Application by Anglian Water Services Limited for an Order Granting Development Consent for the Cambridge Waste Water Treatment Plant Relocation project

The Examining Authority's second written questions and requests for information (ExQ2)

Issued on 31 January 2024

Plan 1 – Site

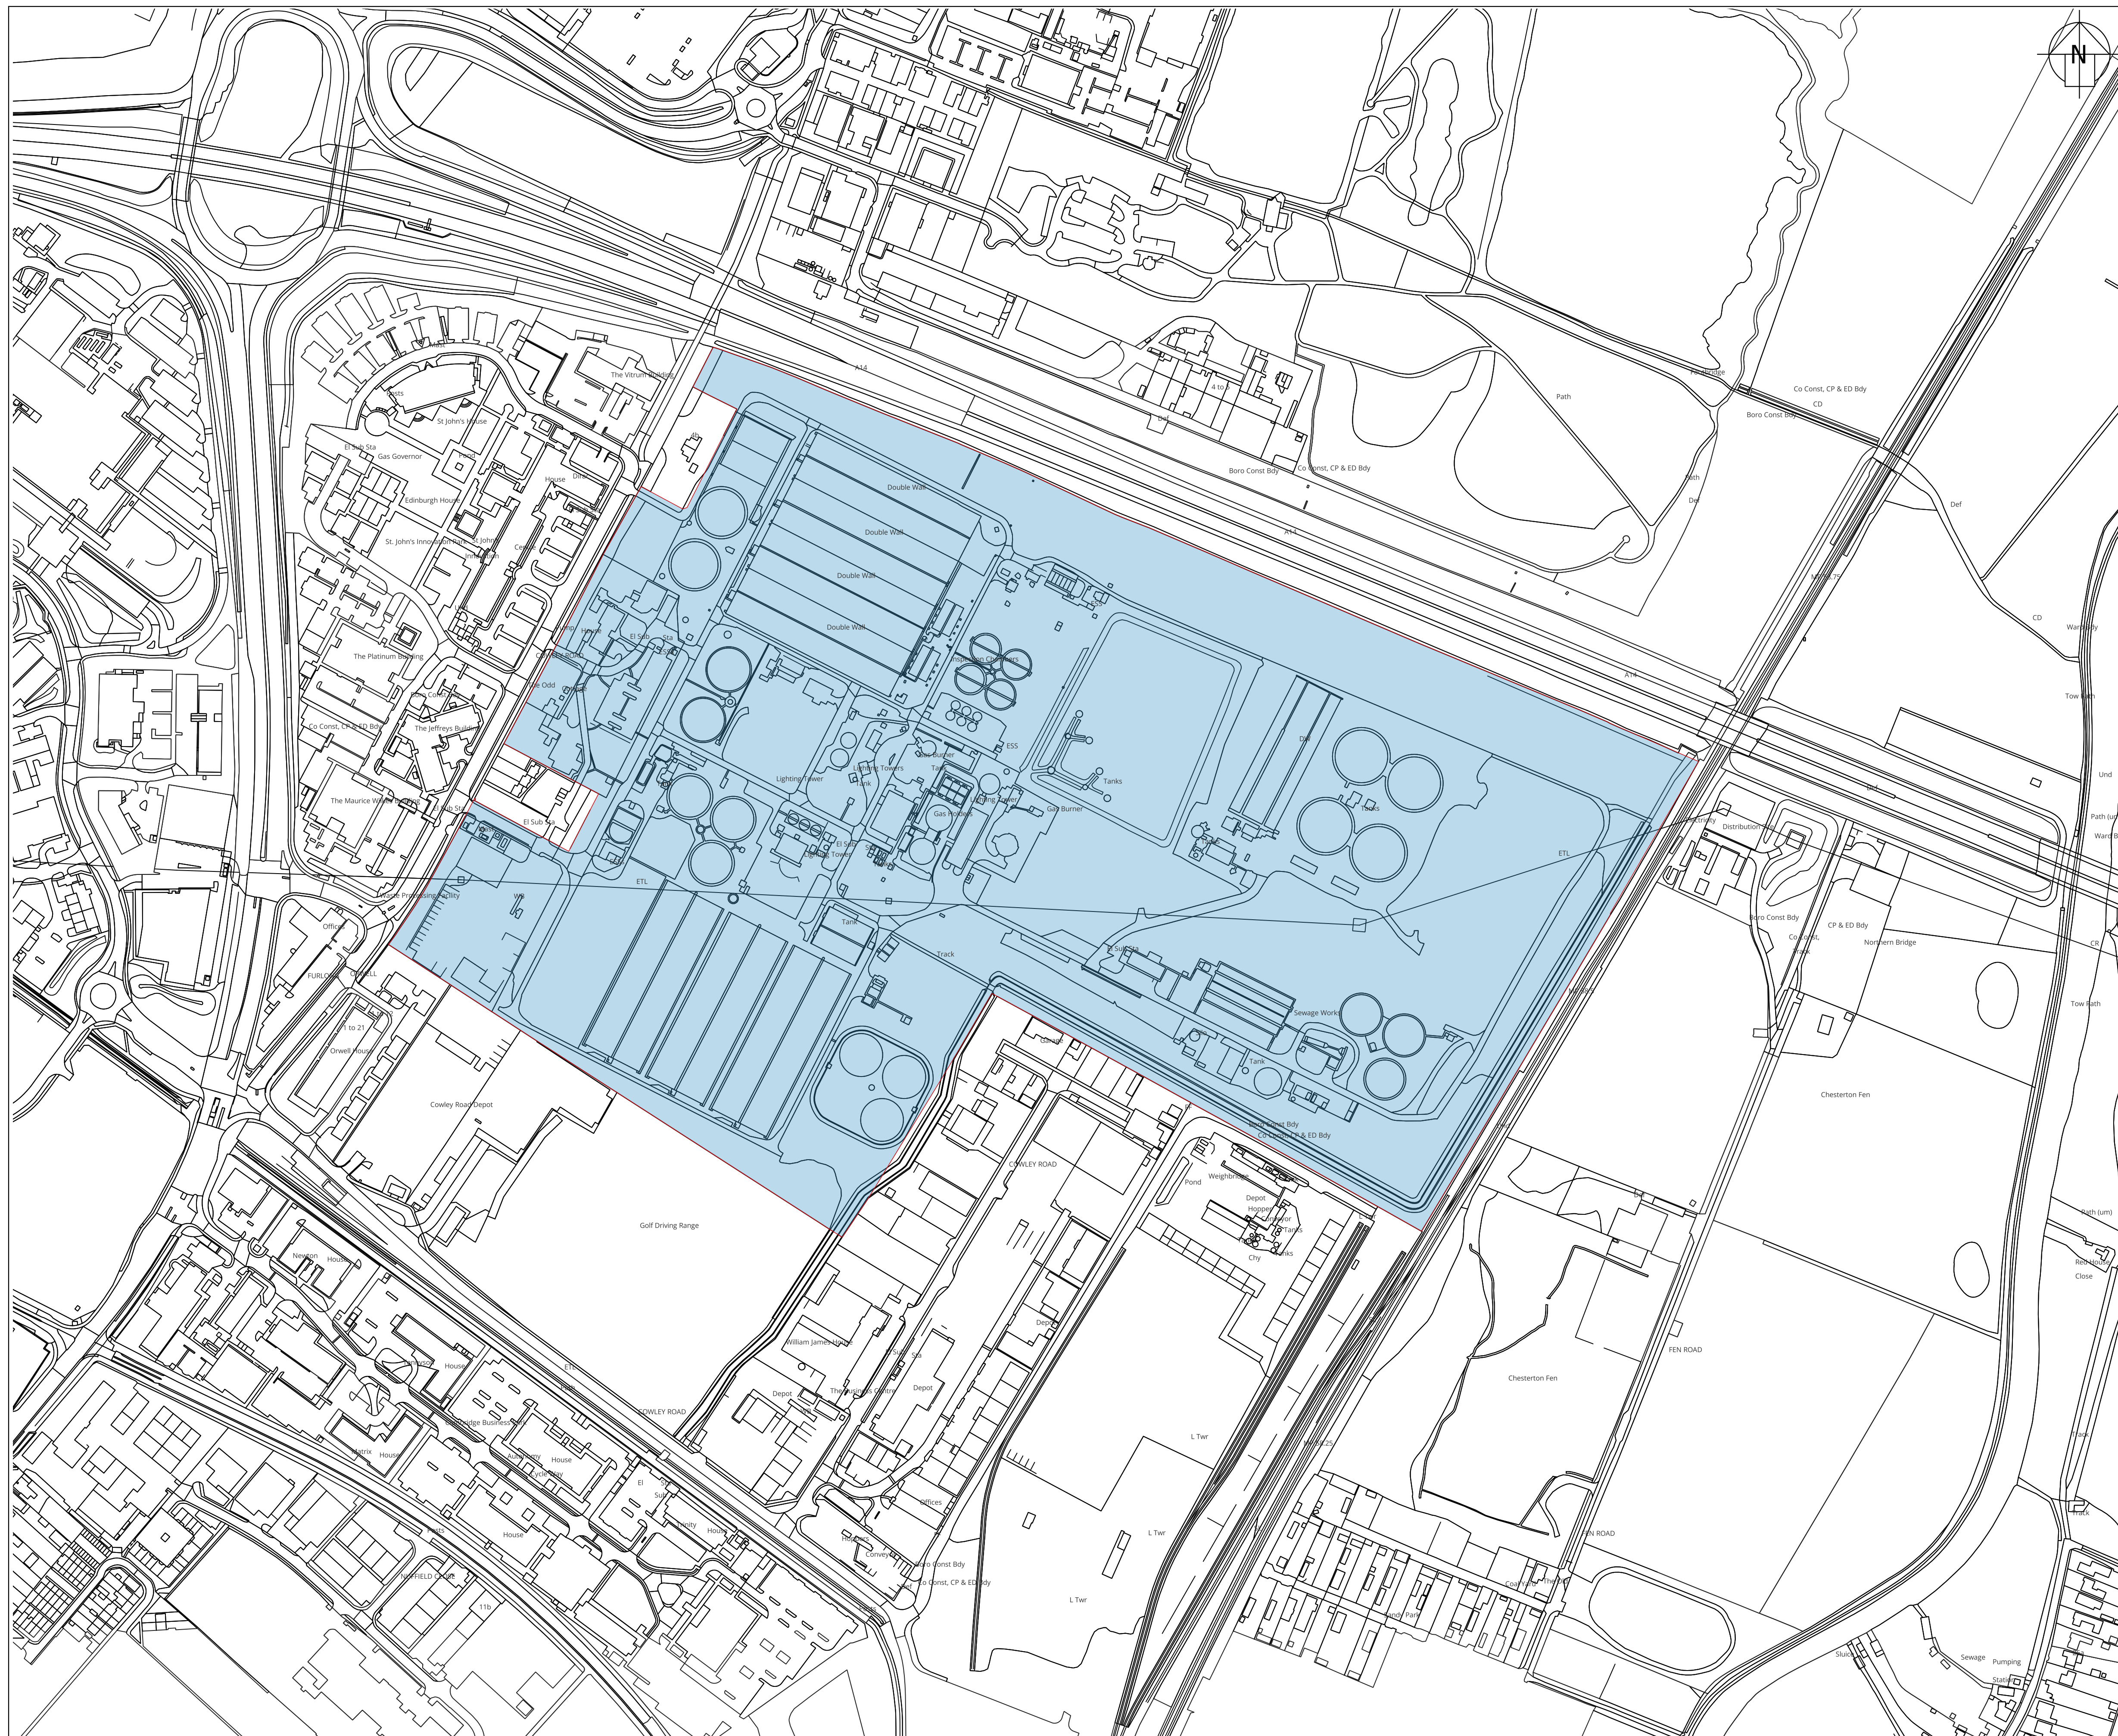
ExQ2	Question to:	Question:
1. General and cross-topic questions		
1.1	Applicant, Cambridgeshire County Council (CCoC)	Legal agreement The draft section 106 (Parking) was updated at D3 [REP3-044] to include a Schedule 2 relating to equestrian signage. Please clarify the necessity for this and why this schedule is not referred to in the main body of the legal agreement.
